Stephen Kilmartin
Planning
Ribbles Valley Borough Council

Email: ecology@lancashire.gov.uk
Your ref: CONECO/3/2013/0854
Our ref: 03/13/0584/ASM/ASP/RS
Date: 6th January 2014

Ecological comments

Planning Application No: **3/2013/0854**
Proposals: **Erection of replacement dwelling**
Location: **Sawley Lodge**
District: **Ribble Valley**

construct 50x75 timber stud baffle walls
board inside only 15mm t g vee softwood

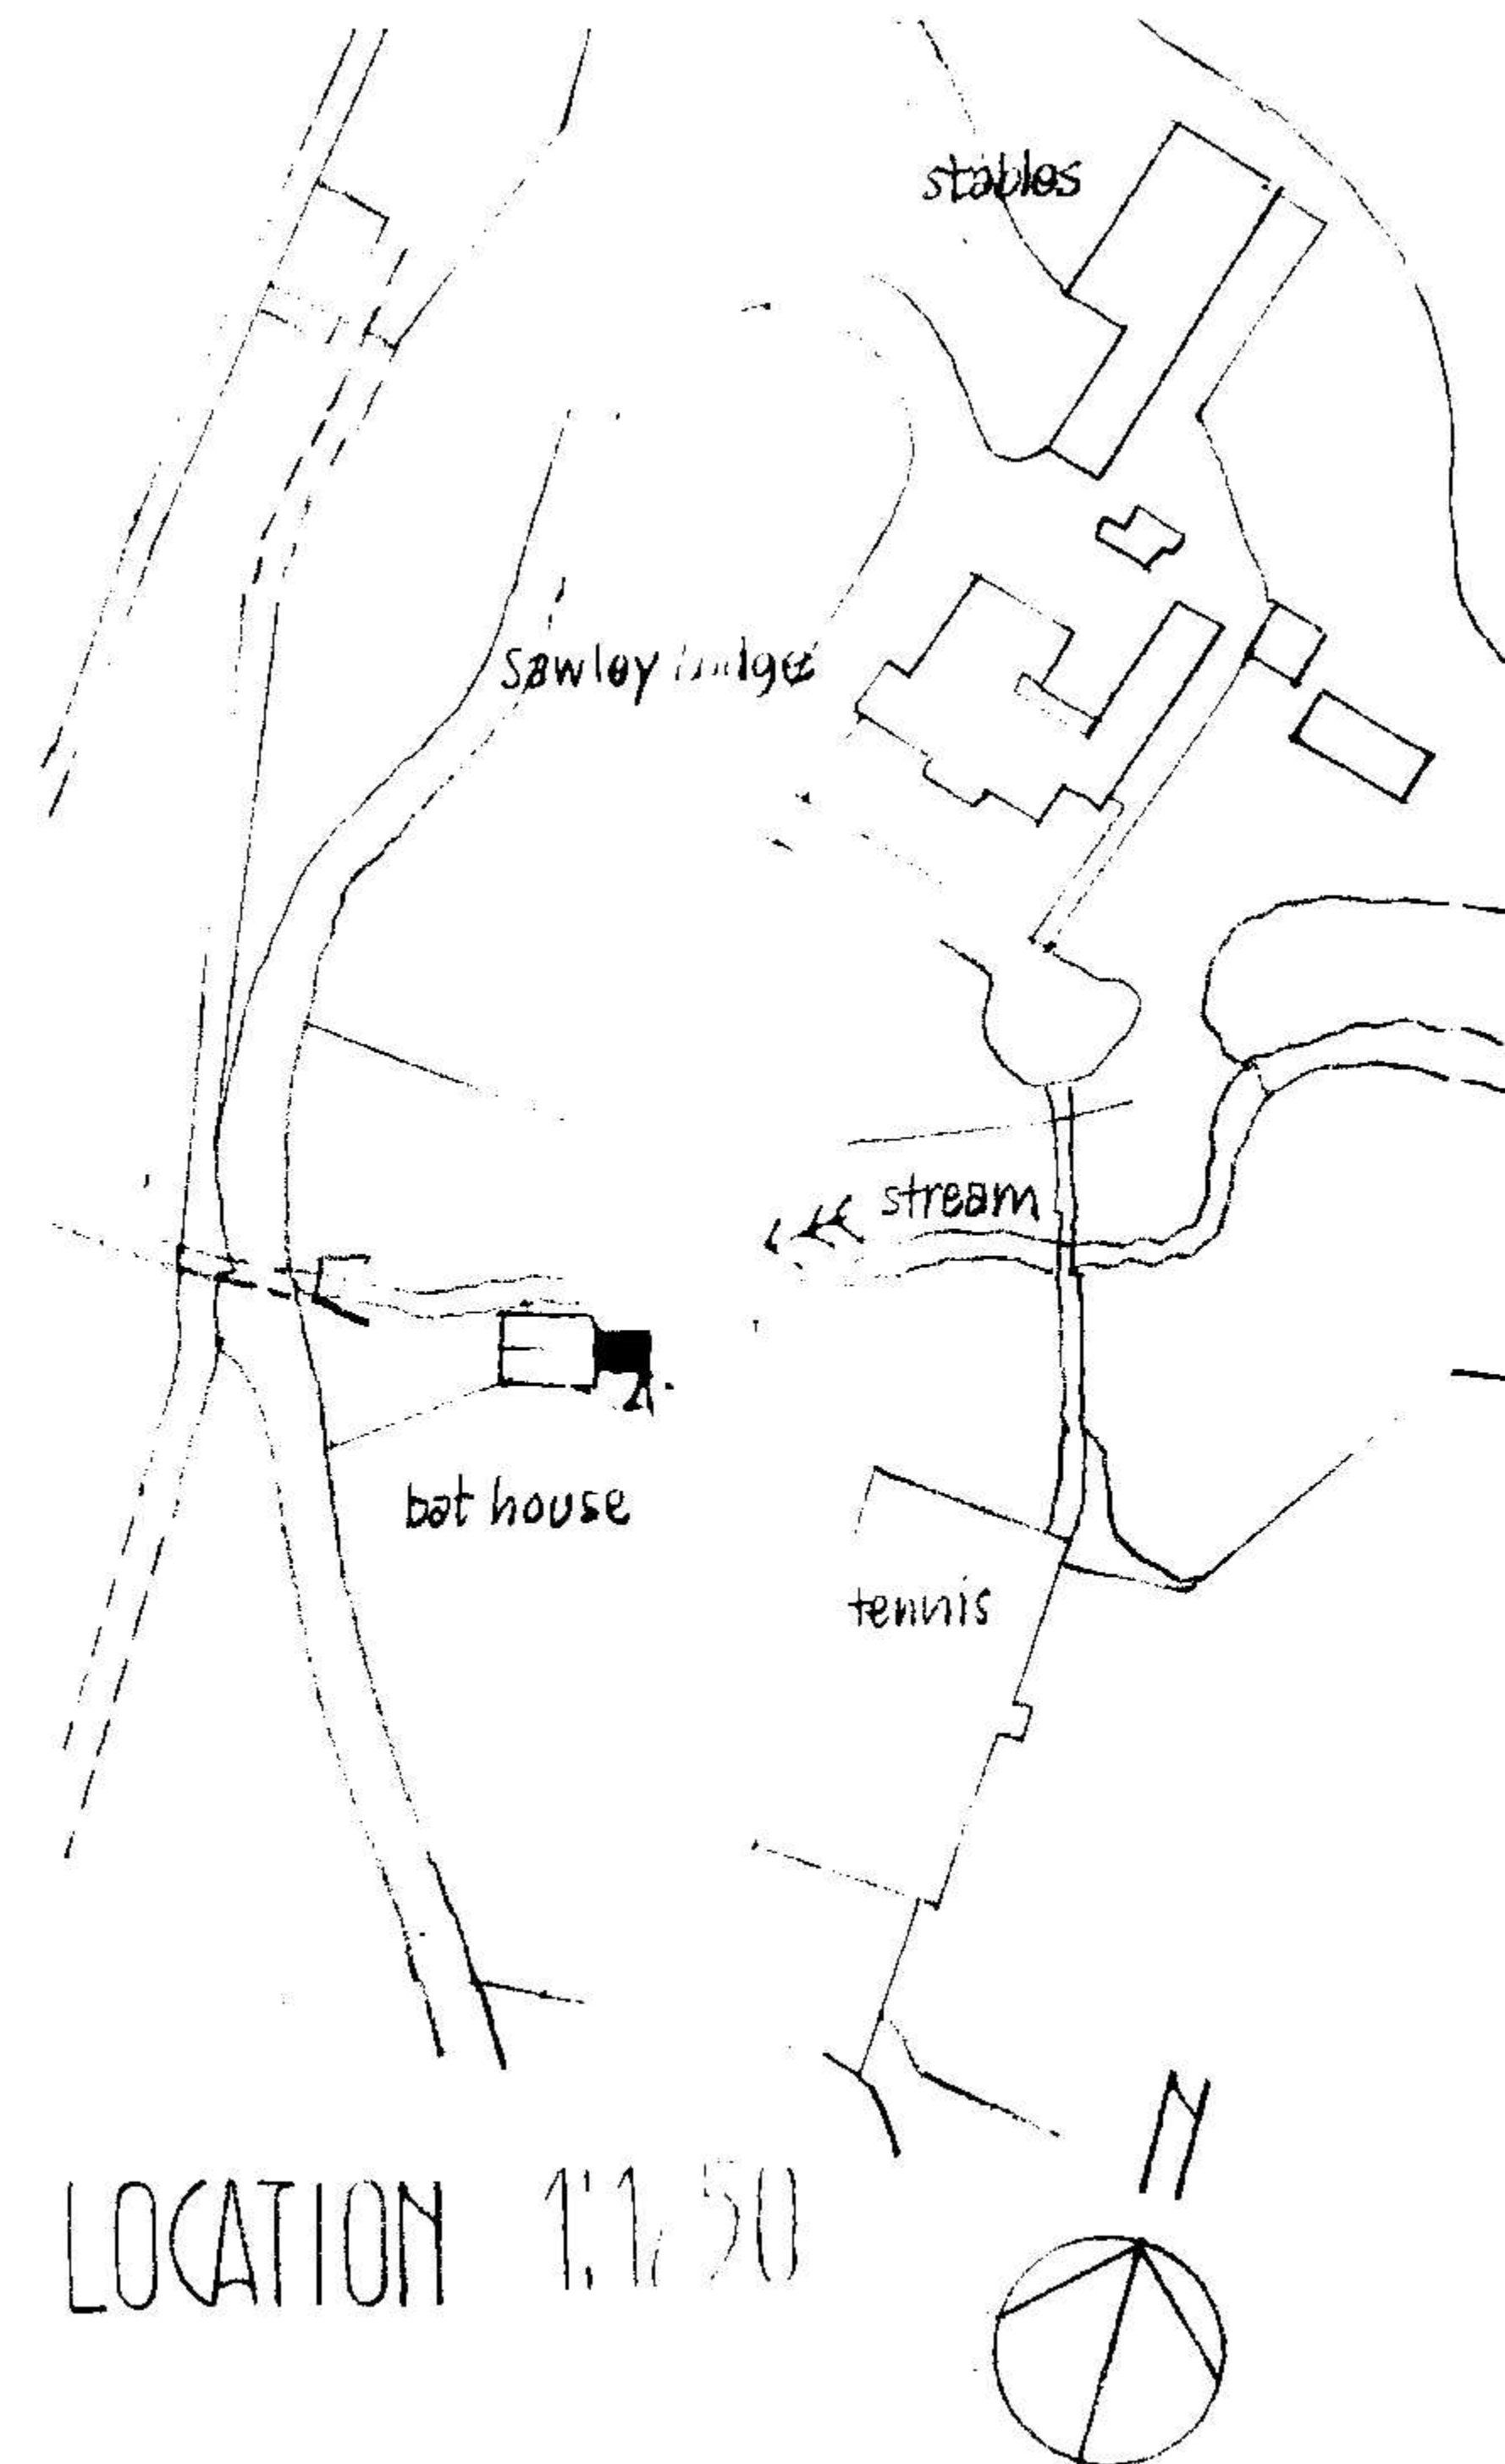
A mitigation method statement has been submitted to address the 3rd test. Although I am not able to comment on these proposals at this stage as the survey work is not yet complete, I note that the proposals involve refurbishment of an existing building and there does not appear be any information regarding the current use of the building by bats and birds. Surveys to establish the use by bats and birds (barn owls and nesting birds) of any existing building proposed to be used as mitigation would need to be submitted prior to determination of the application.

- Assessments/surveys to establish the use of the power house/hydro building to be refurbished by bats and birds (including barn owls and nesting birds)
